**CYNGOR SIR YNYS MÔN
ISLE OF ANGLESEY COUNTY COUNCIL**
Canolfan Fusnes Môn • Anglesey Business Centre
Parc Busnes Bryn Cefni • Bryn Cefni Business Park
LLANGEFNI
Ynys Môn • Isle of Anglesey
LL77 7XA

Dyddiad / Date: 10th April 2019

Wylfa Newydd DCO Examination EN010007 - Deadline 9 Submission

IACC has reviewed Horizon's Deadline 8 submission and has the following comments;

Figure 1-6 A5025 Off-line Highway Improvements Power Station Access Road Junction

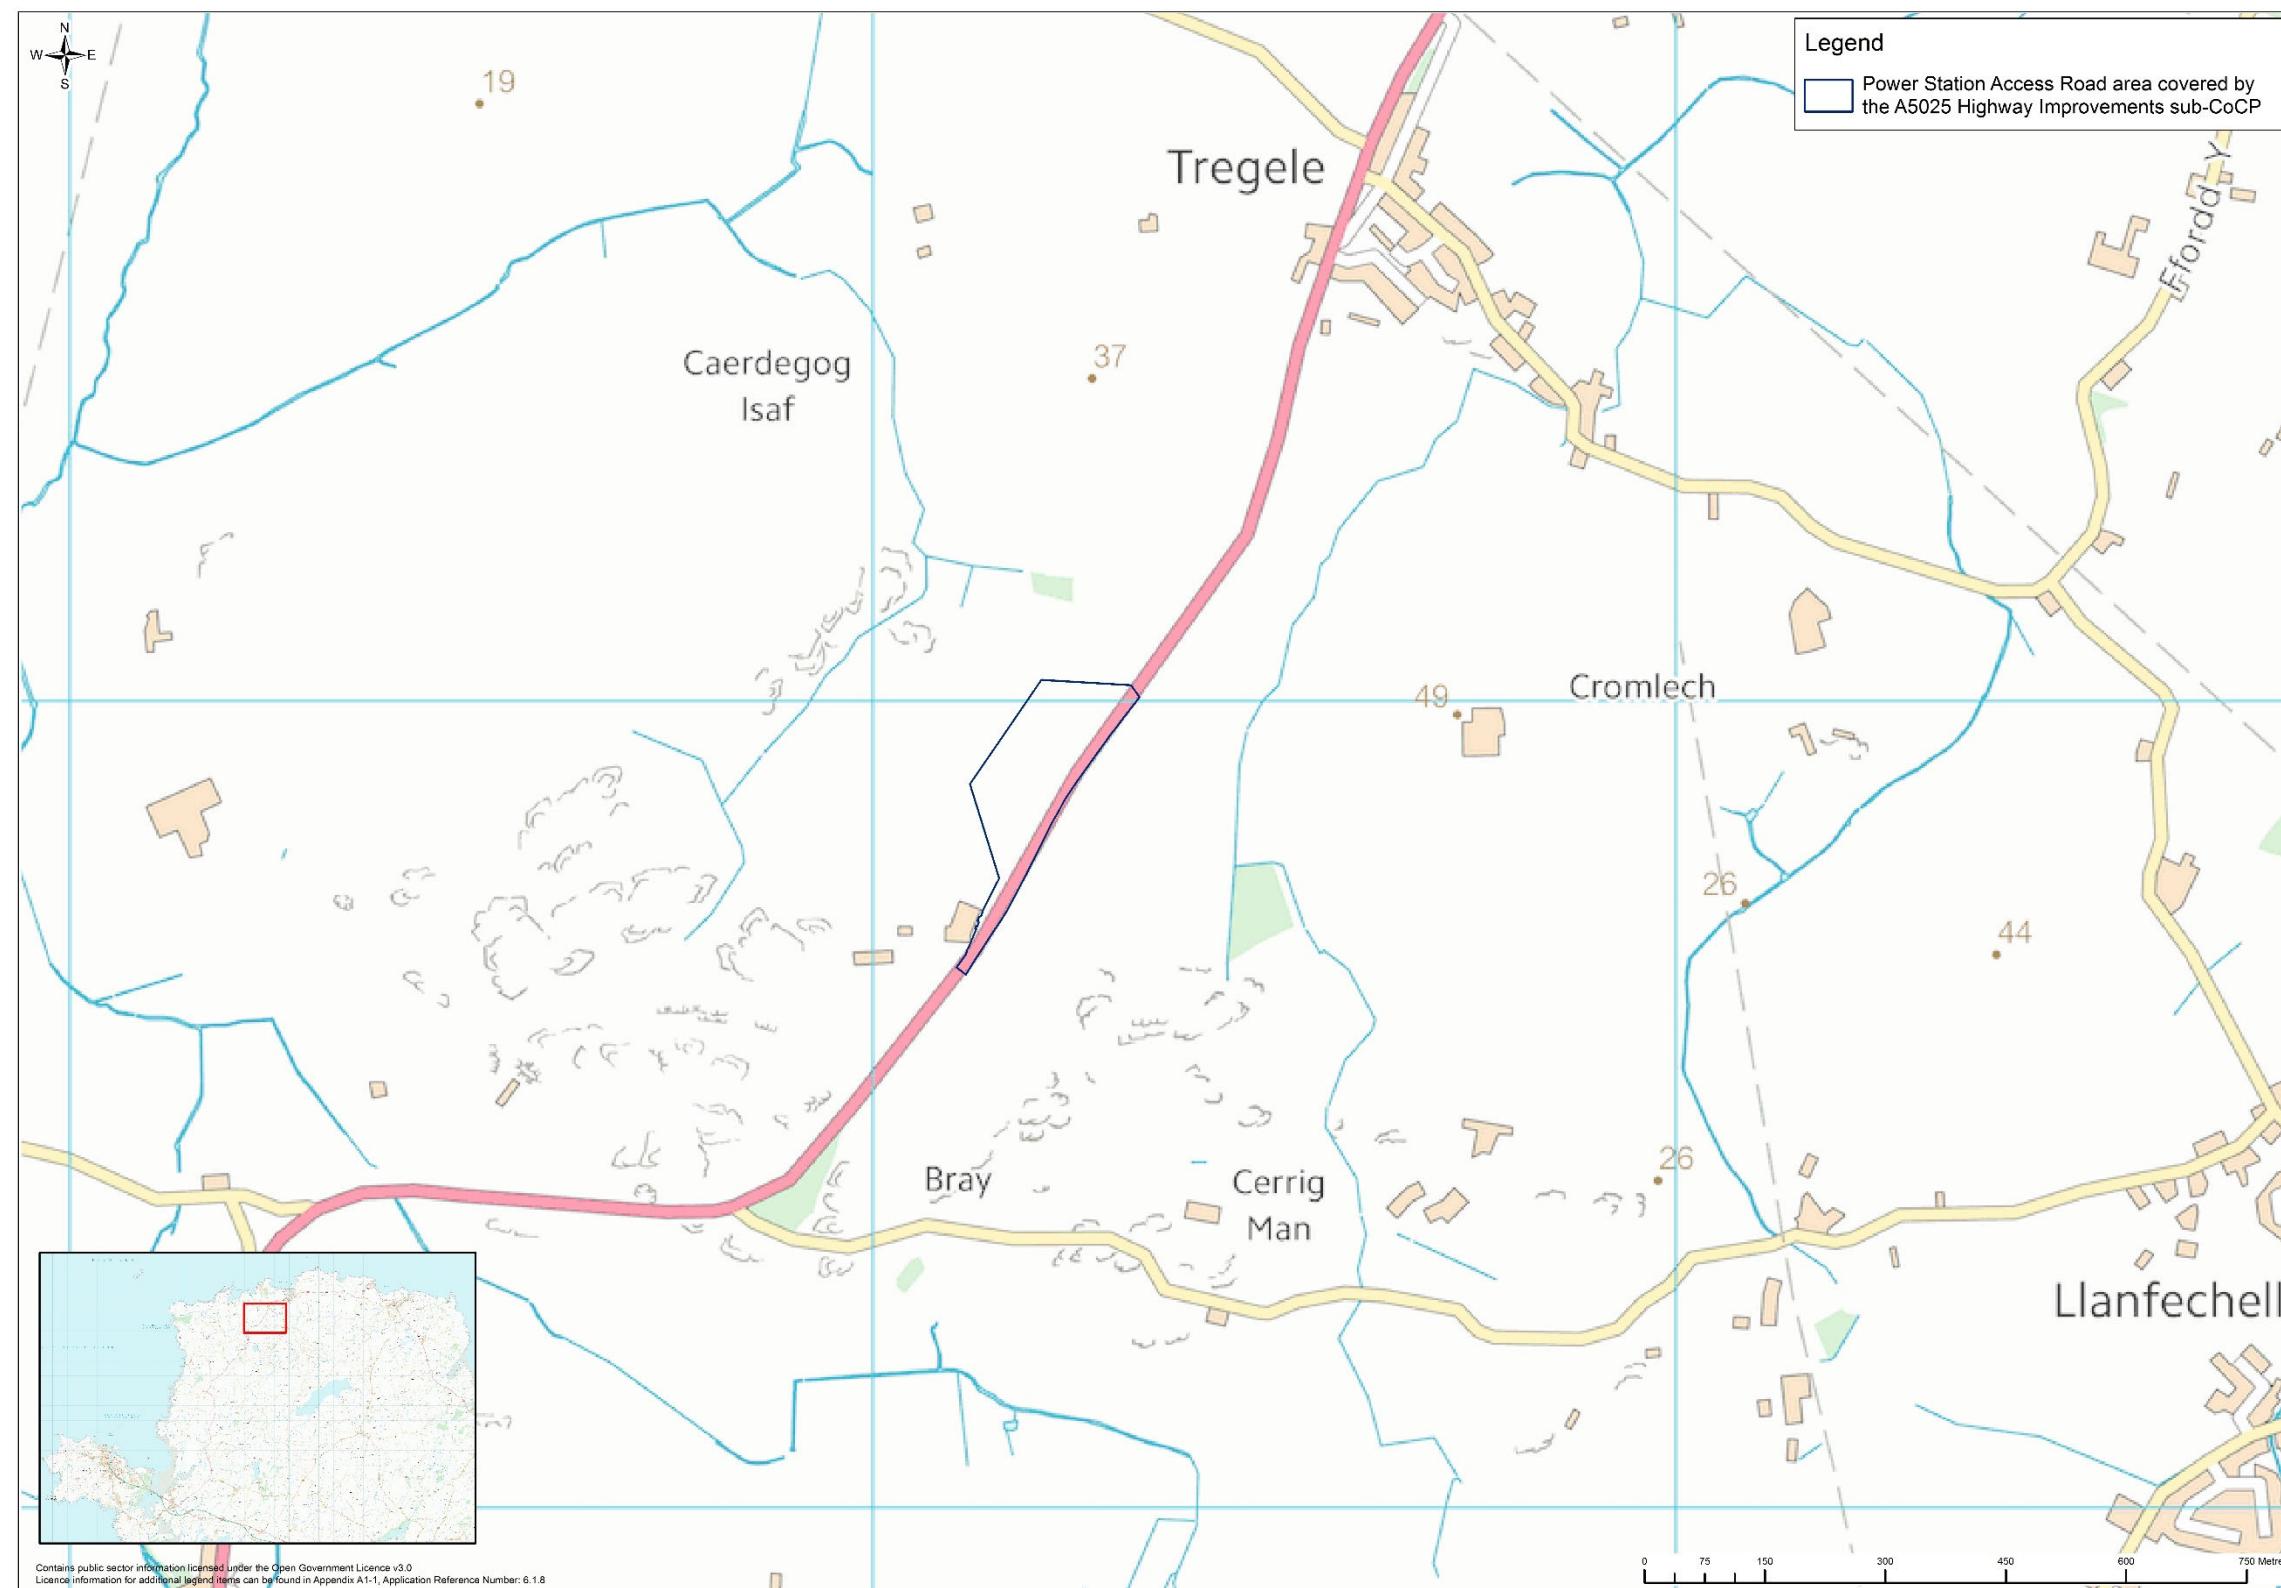
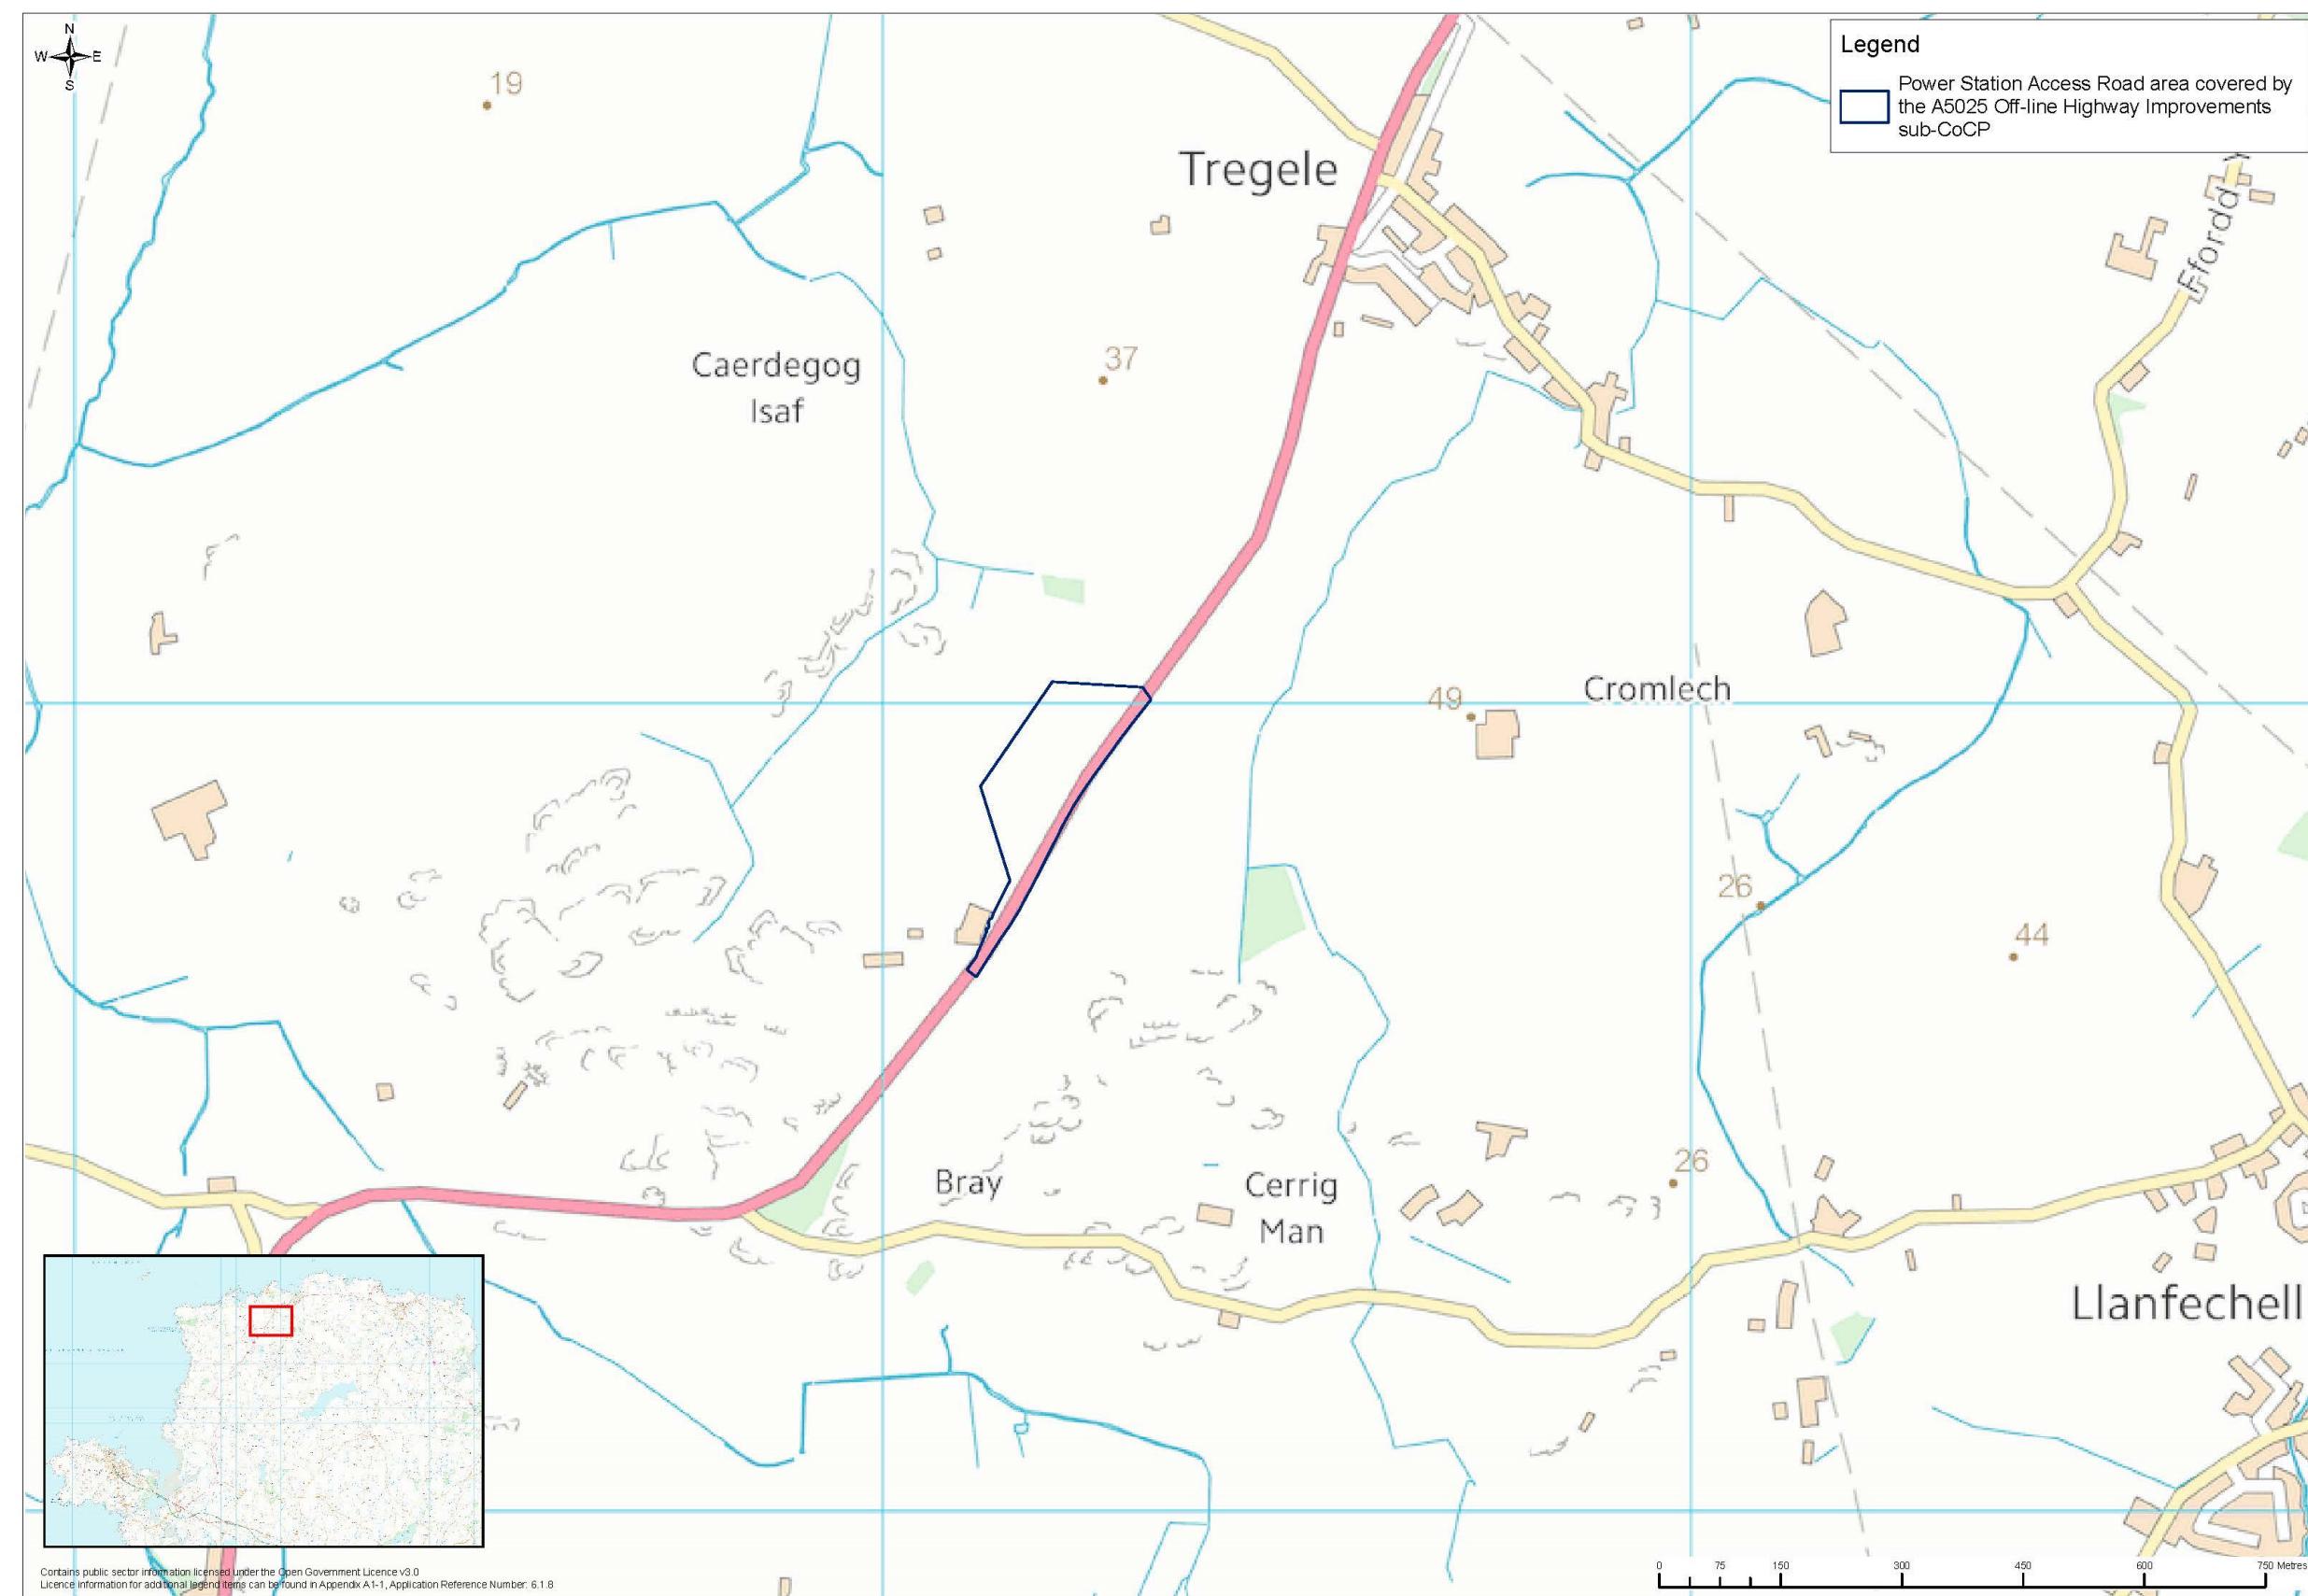
As a direct consequence of implementing the WNDA junction access arrangement, the existing vehicular turning area (circled red below) will be lost.

To mitigate for this loss, the IACC seeks the provision of a new (alternative) vehicle turning area adjacent the existing layby as part of the WNDA junction access arrangement works. The proposed location of the new vehicle turning area is shown below.

To enable this proposed turning head to be dedicated as public highway, the purple dashed line (Centreline of Proposed highway) would require extending on the Rights of Way plan.

IACC were expecting the relevant plans including A5025 Off Line Highway Improvements Section 9- Power Station Access Road Junction Proposed General Alignment WN0902-HZDCO-OHW-DRG-00063 Revision 4.0 (2.6.1 WNDA – Power Station Sire Plans REP8-027) and A5025 Off-line Highway Improvements Section 9 – Power Station Access Road Junction Right of Way WN0902-HZDCO-ROW-DRG-00030 (2.4 Right of Way Plans Revision 3.0 REP8-024) to have been updated by HNP in their Deadline 8 submission in order to allow the DCO to consent this proposal.

IACC are requesting that the plans referred to above and any other relevant plans are revised accordingly to accommodate this proposal.

Discussions have progressed between IACC and HNP regarding this matter and agreement has been reached which is consistent with the above proposal.
